- Estuary Court & Importance of our Greens
- TII Construction Programme for Estuary Court
- Solutions Proposed re-alignment on R132
- TII's response to our proposed re-alignment
- Our proposal
- Closer Look at the main Road Junctions
- Multiple Benefits of re-alignment proposal
- Greenway opportunity
- Value Engineering Precast Tunnel
- R132 Key enabler to solution
- Conclusion

Proposed Re-alignment – TII Response to Estuary Court Submission

Alternative – Re-alignment onto Southbound side of R132

Outline Construction Programme

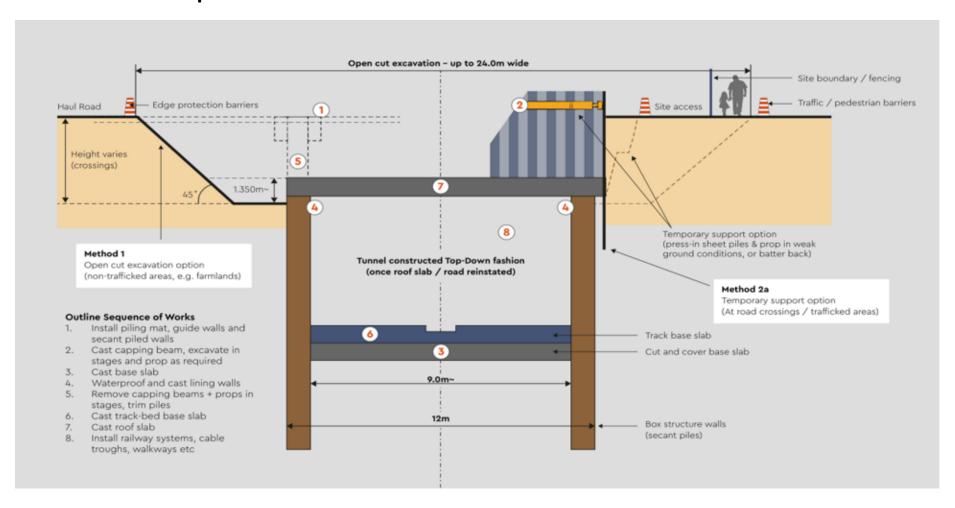
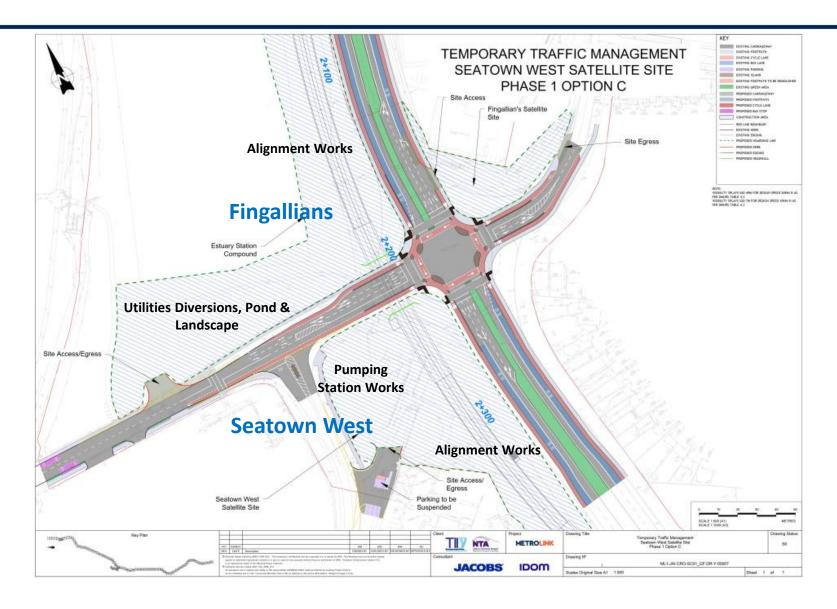
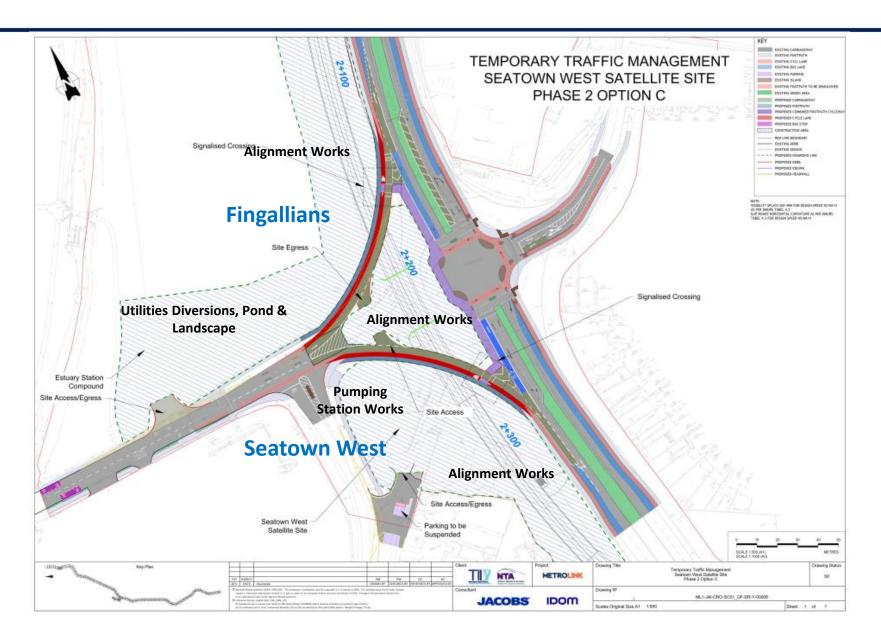
36 Months Construction Programme X 19
Working Days per Month (excl. Sat)
= 684 working Days for Estuary Court (105m of Cut and Cover)

Therefore **6.5 days per M** of Metrolink through Estuary Court.

But TII say Metrolink will be completed in 8 – 9 years. Why so long in Estuary Court?
